Your Ref: OWPC15337
Our Ref: FG/115/17/PL
Please ask for:
Mr D Easton

4 No. bungalows
44 Ferringham Lane Ferring

Thank you for your internet comments made on 23rd August 2017 which has been recorded as **'an objection'** with the comments as follows:

DWG No. 628-05 rev.

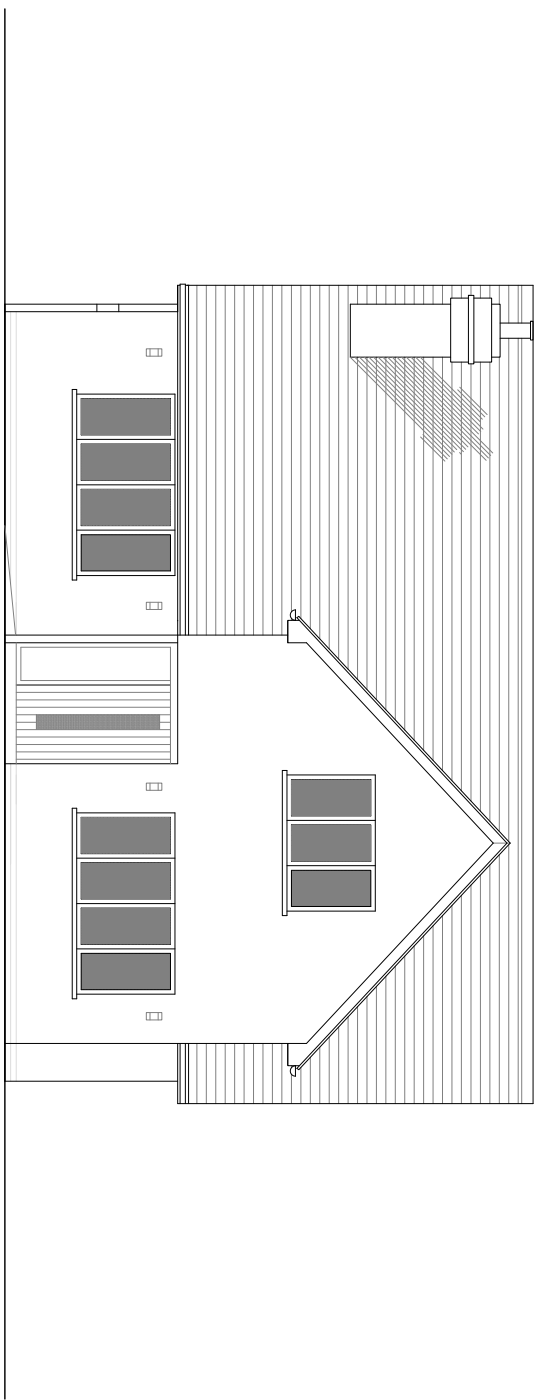
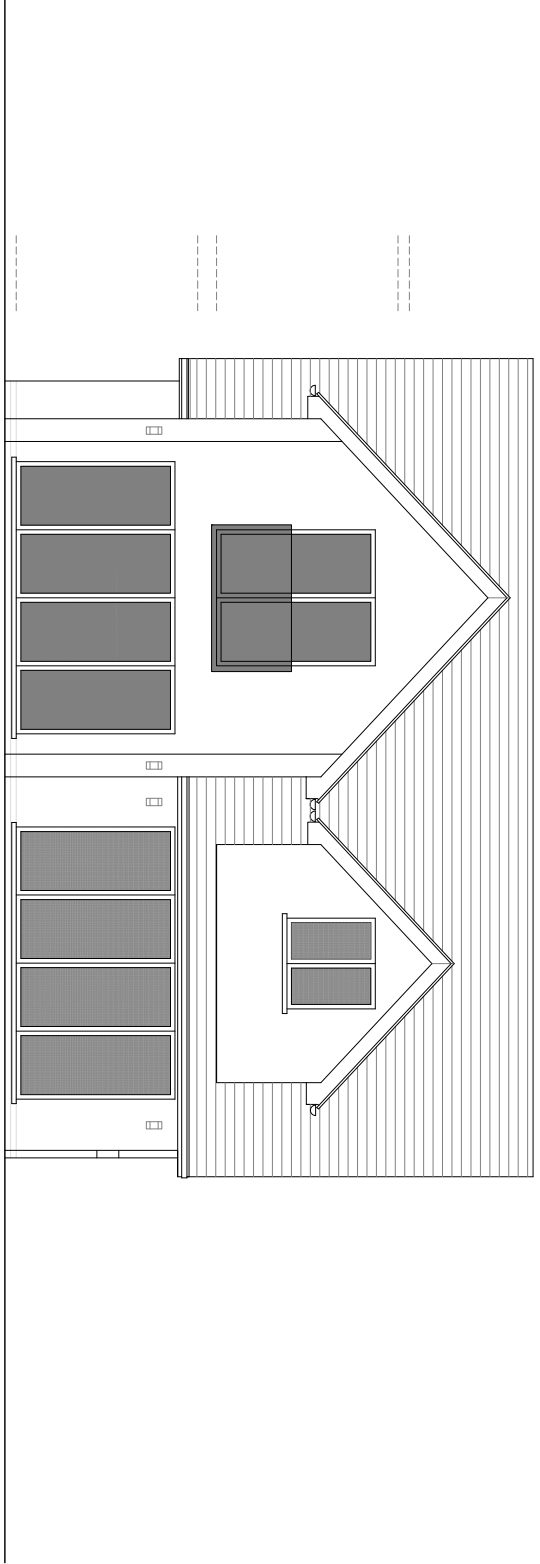
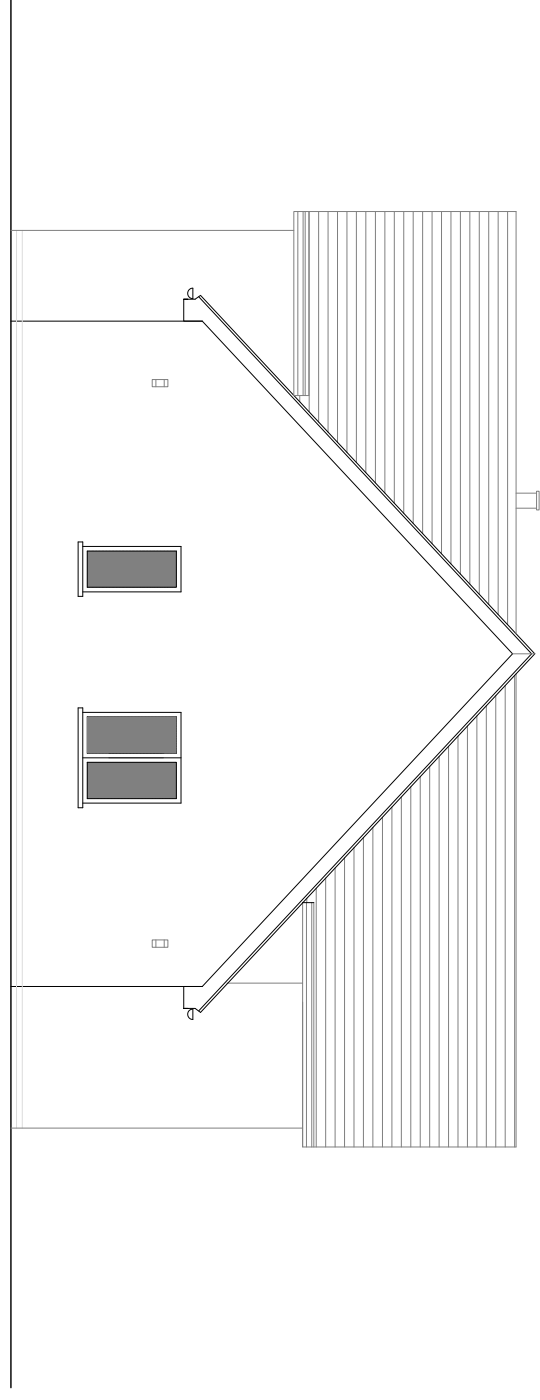
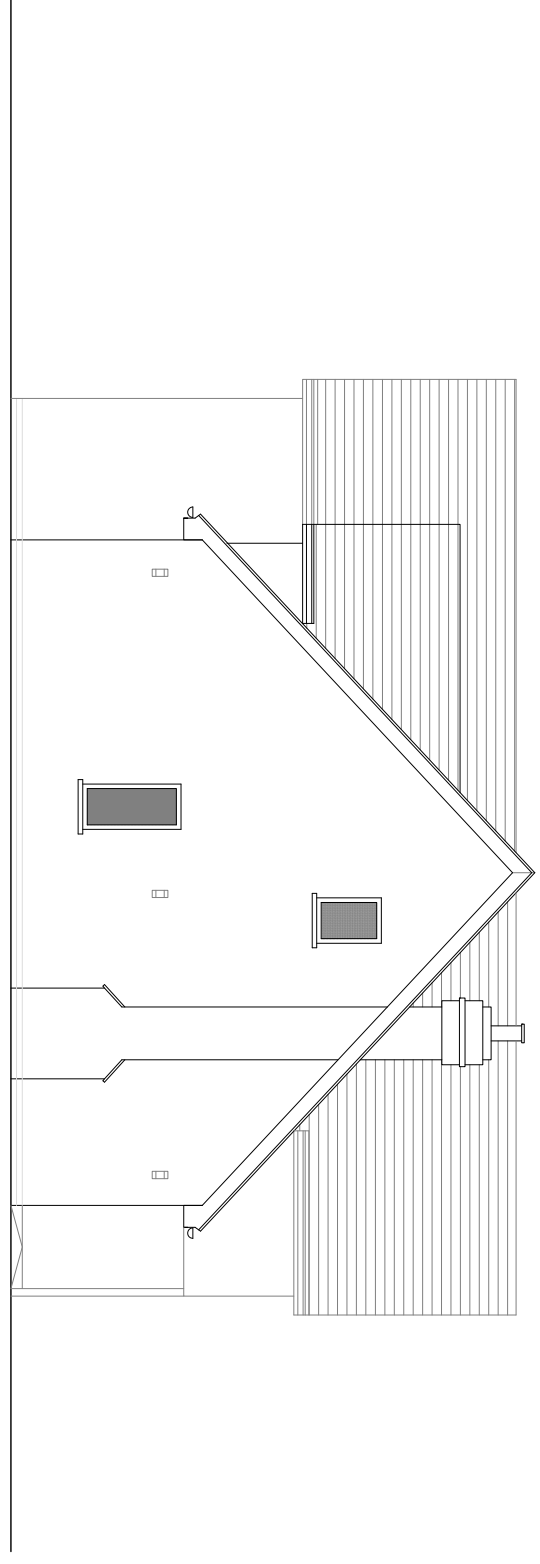
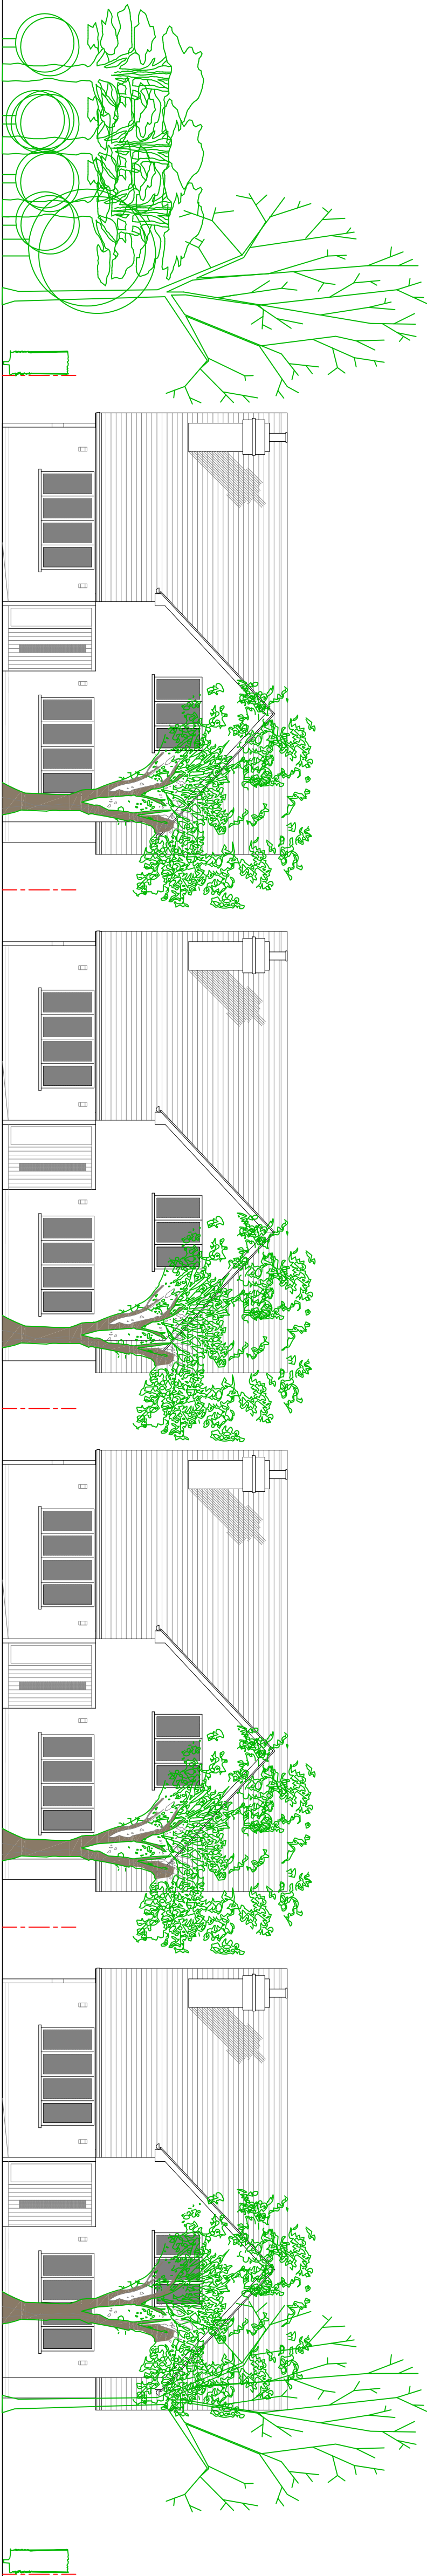
Ferring Parish Council appreciate that outline planning has already been granted on appeal, however this was for one storey properties, and this application is two storey properties.

The revised stature of the properties will have an overbearing impact on neighbouring properties at the north end of Little Paddocks who will lose their privacy and undoubtedly experience additional noise and bright lighting from vehicles.
